Re: TOWNHOUSE ADDITION (K-17/D91)
501 Quincy Place SE
Approval of Permanent Certificate of Occupancy (C.O.)
Engineer's Stamp dated 01/18/2005(K-17/D91)
Certification dated 05/06/2005

RE: FINAL CERTIFICATION OF GRADING PLAN FOR TOWNHOUSE ADDITION,
501 QUINCY PLACE SE (K17-D91)

**Re: Townhouse Addition, 501 Quincy Place SE, Grading and Drainage Plan
Engineer's Stamp dated 1-18-05 (K17-D91)**

Re: Townhouse Addition, 501 Quincy Place SE, Traffic Circulation Layout
Architect's Stamp dated 12-30-04 (K17-D91)

Date:
14 December 2004
Sheet:
TCL PLAN

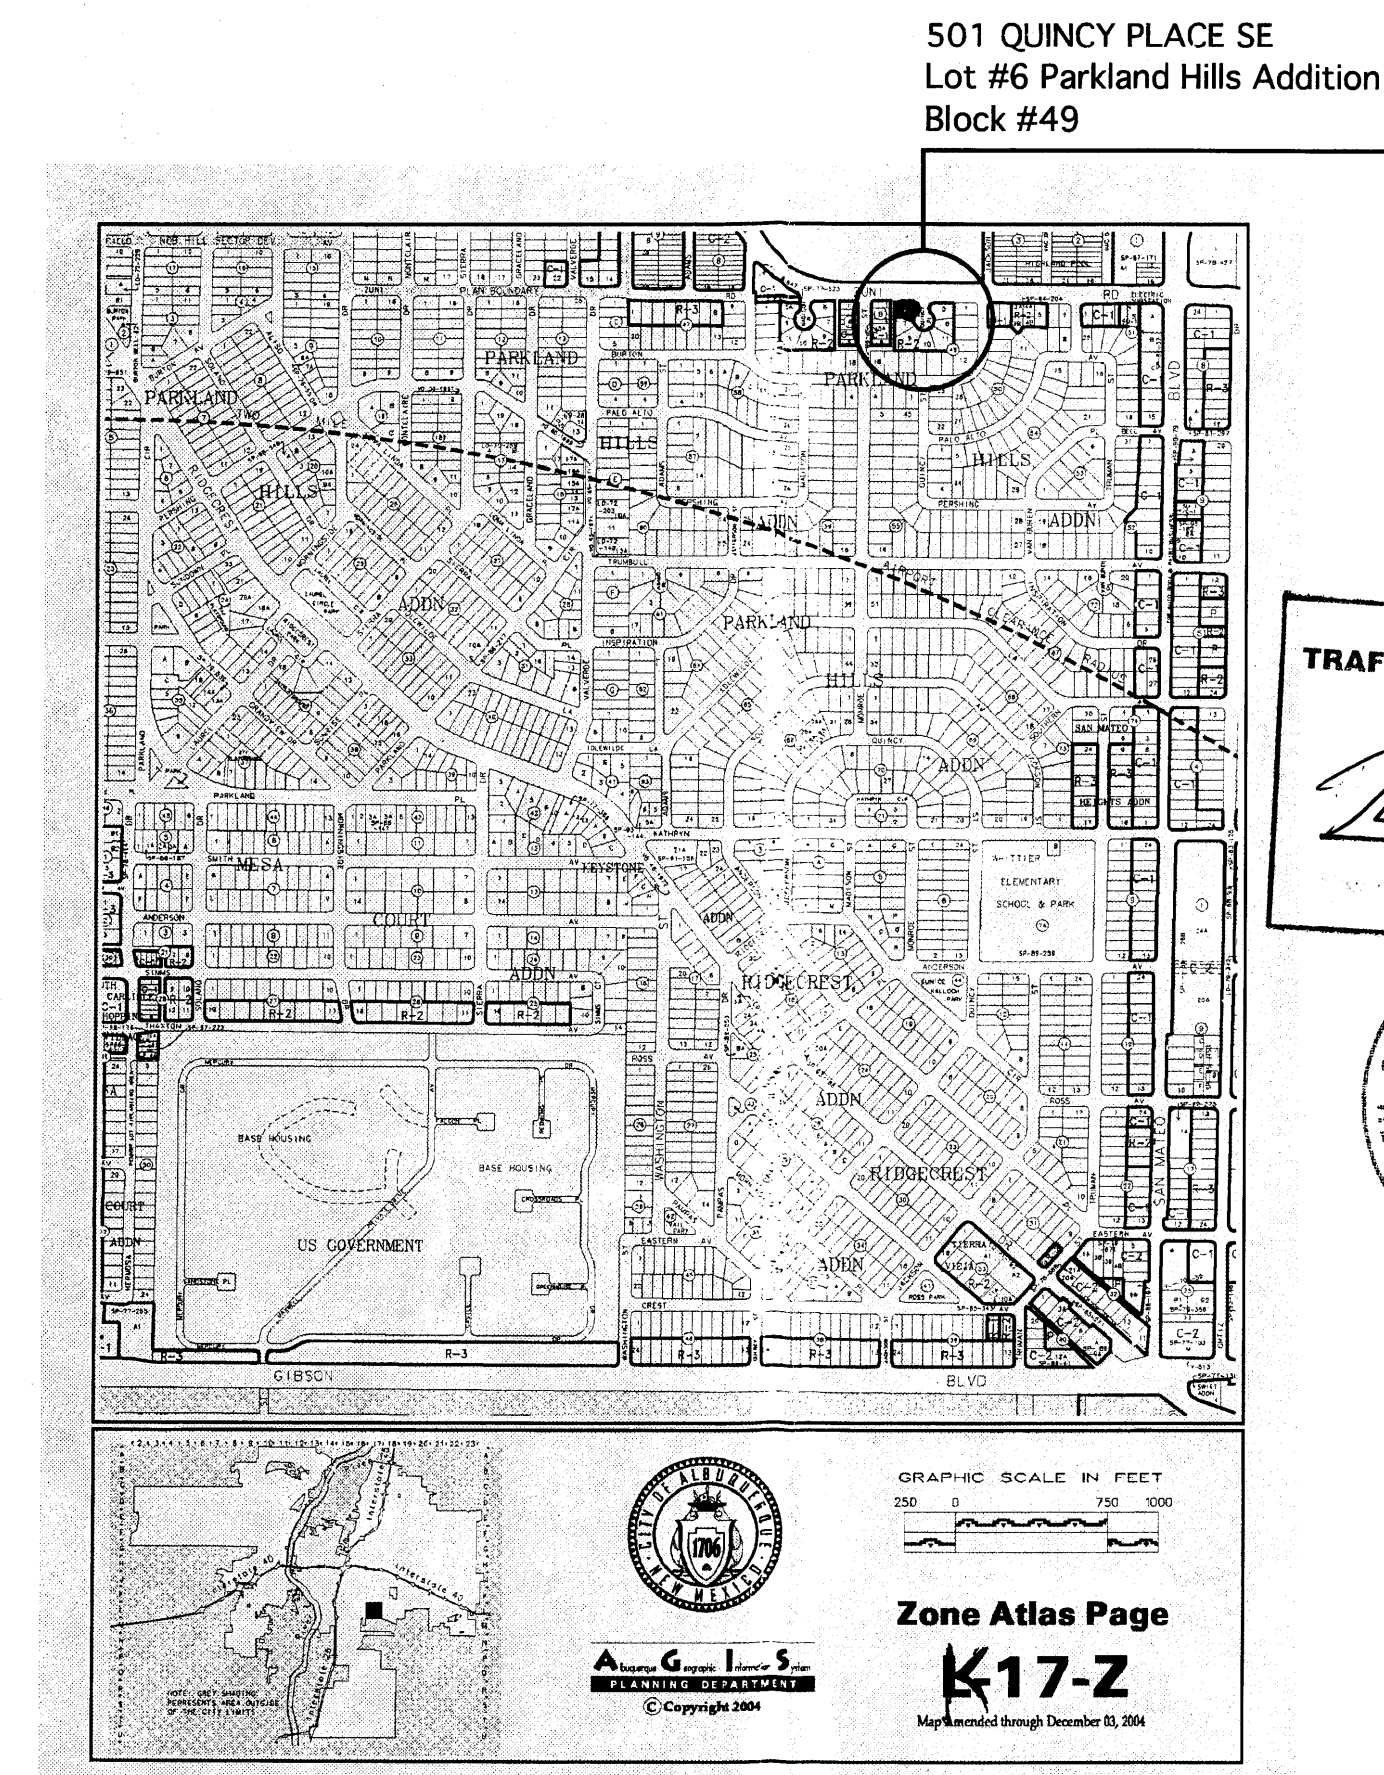
Is the existing ramp ADA compliant?

Do they need to widen the 3 1/2 ft existing sidewalk?
